## Request for Clarification of Information

Address: 44 Maggie Lane

Permit #: 2016-02272

Date: 10/17/2016

- FOUNDATION PLAN**
- NEW WALLS - SHADED.
 - 4' FROST WALLS - 8' RE-INFORCED ON 8'x16" CONTINUOUS FOOTINGS.

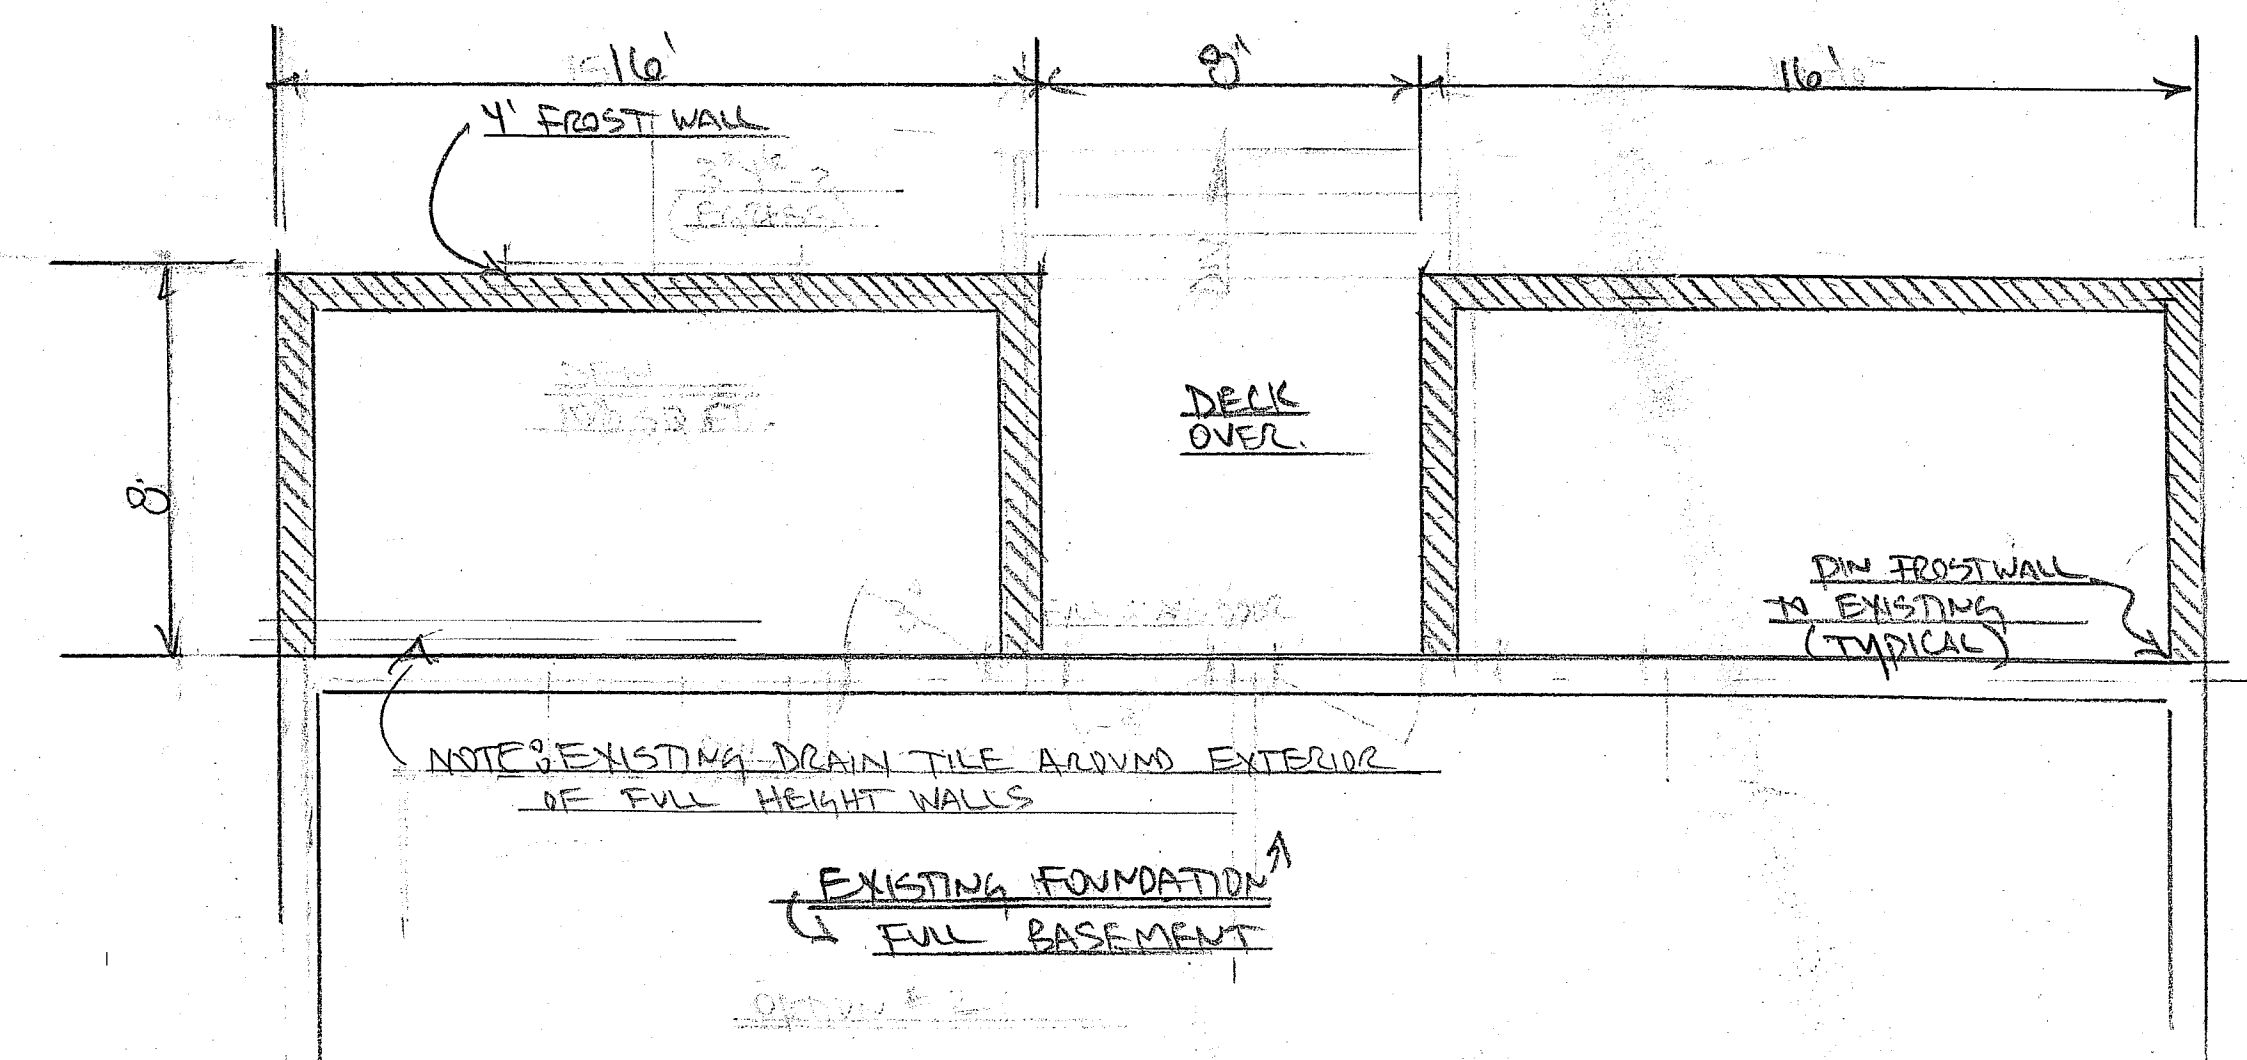
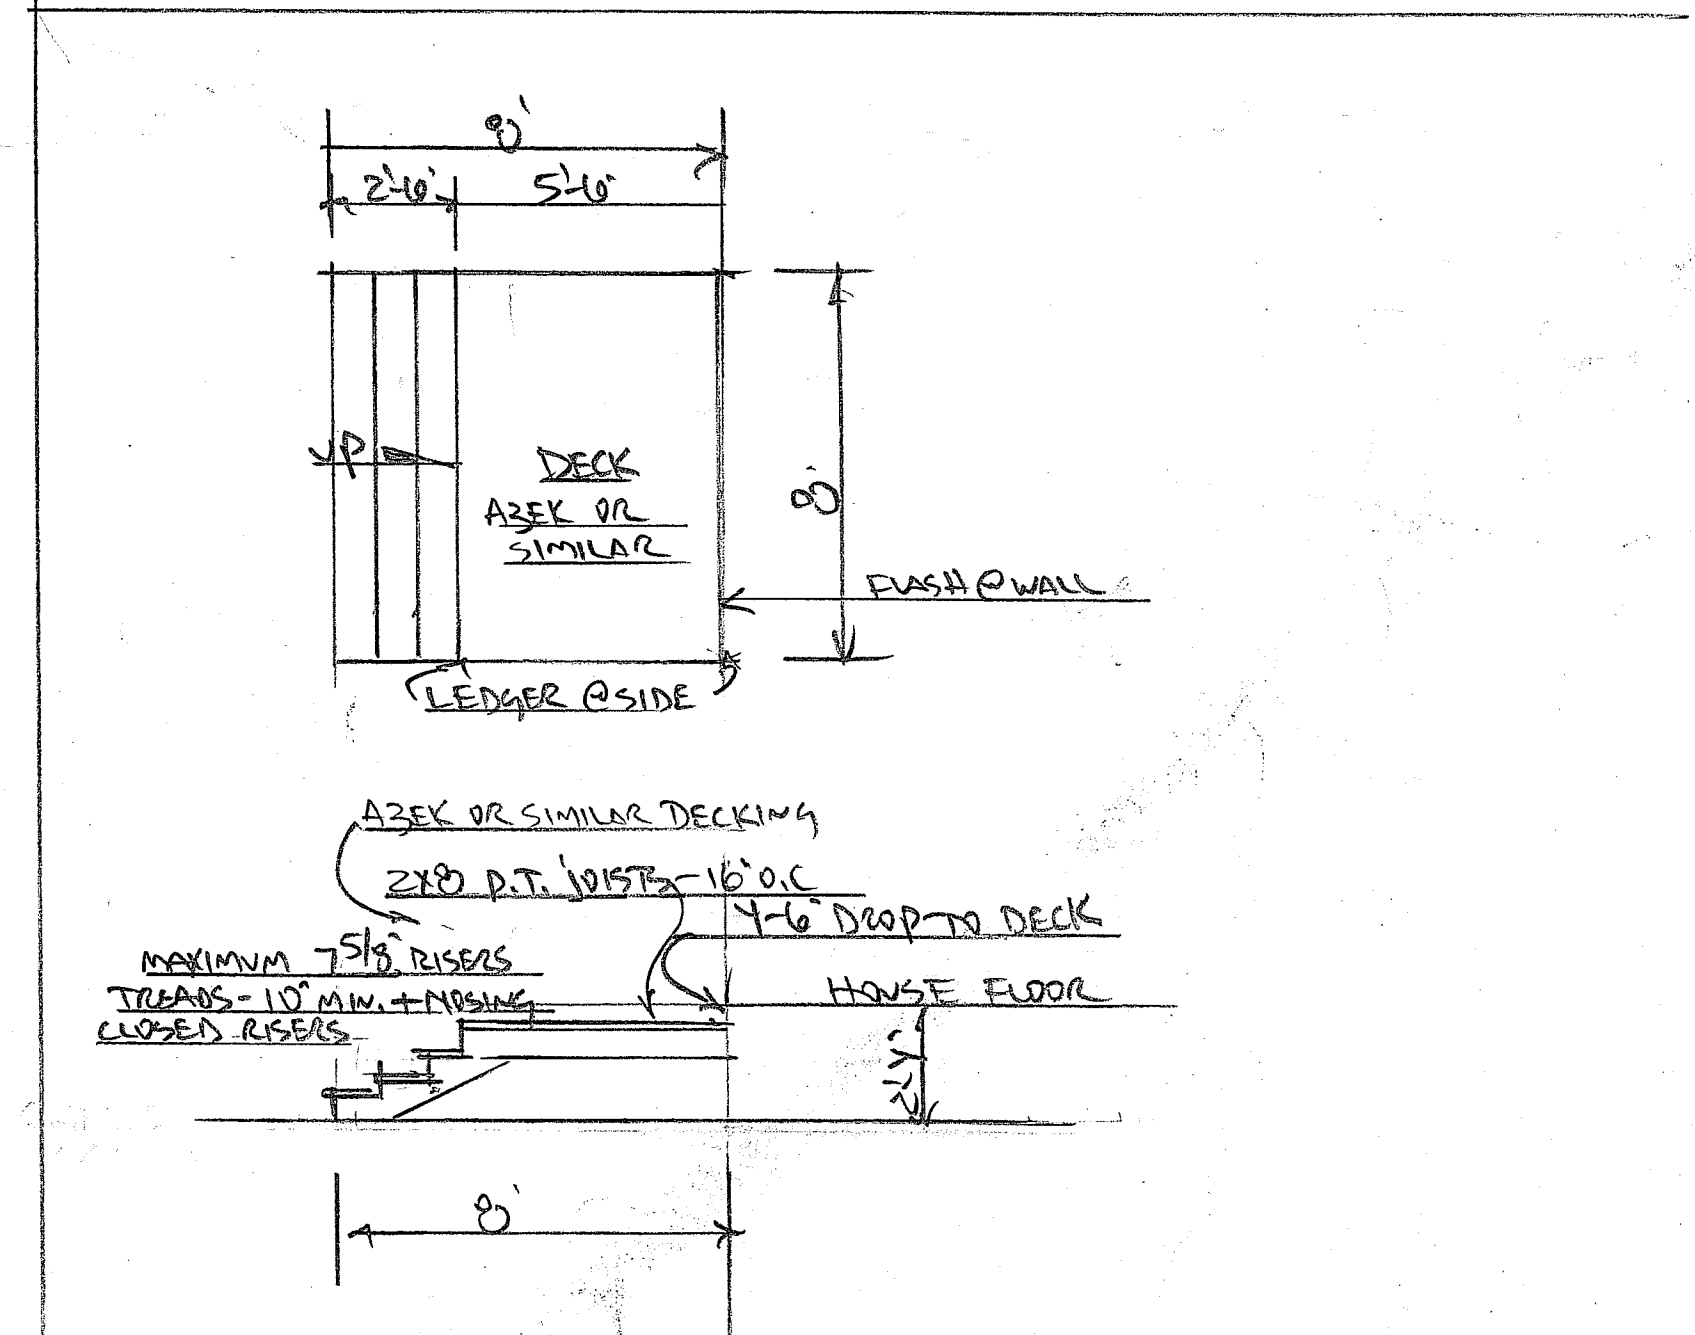
1. Show the location of the Drainage pipes at the foundation - *AROUND EXISTING OF FULL FOUNDATION. INSTALLING NEW PIPES AROUND 4' FROST WALL FOR DIFFICULT + NO PURPOSE.*

2. Will the crawl space be filled back up to grade or left open down to the footing as shown in the drawing? *FILLED TO GRADE.*
3. What are the sizes of on the crawl space vents as shown on the drawing? *NONE.*

4. Specify the size and spacing of the anchor bolts *1/2" BOLTS - 24" O.C.*
5. Call out the header sizes for the new windows *3-2x8 KD spruce w/ plywood.*

6. Call out full dimension of windows in addition. *@ unit R.O. IS. 3'-2 1/8" x 4'-8 7/8" H. MULLION = 6'-4" W x 4'-8 7/8" H. (6'-3 3/16" x 4'-9 1/4" IN 200 SERIES - ANDERSON)*

7. Will there be windows on the sides of the additions? *NO.*
8. Specify the species of wood being used for the floor joist and roof rafters *KD. SPURCE.*

9. Specify the grade of insulation *F.G. AND RIGID FOAM, 2x6 STUDS. R-25 IN FLOOR. R 49 IN ROOF - R 23 MIN. IN WALLS - 6" F.G. + 1" RIGID FOAM*
10. Where would roof end up if you changed the slope to 3:12 - *IT WOULD BE TOO HIGH - WE HAVE EXISTING WINDOWS ABOVE, AND NEED SPACE FOR FLASHING.*

11. How will the new roof rafters be connected to the existing house? *A 2x8 LEDGER WILL BE LAG SCREWED IN STUDS - 16" O.C (EXISTING WALL)*
12. Specify new framing in fill of existing bay windows. *2x6 KD spruce, 16 O.C, 1/2" CDX, tyvek, vinyl - 1/2" sheetrock interior.*

13. What type of sheathing is being used in the new exterior walls?

*1/2" CDX - 5 ply.*
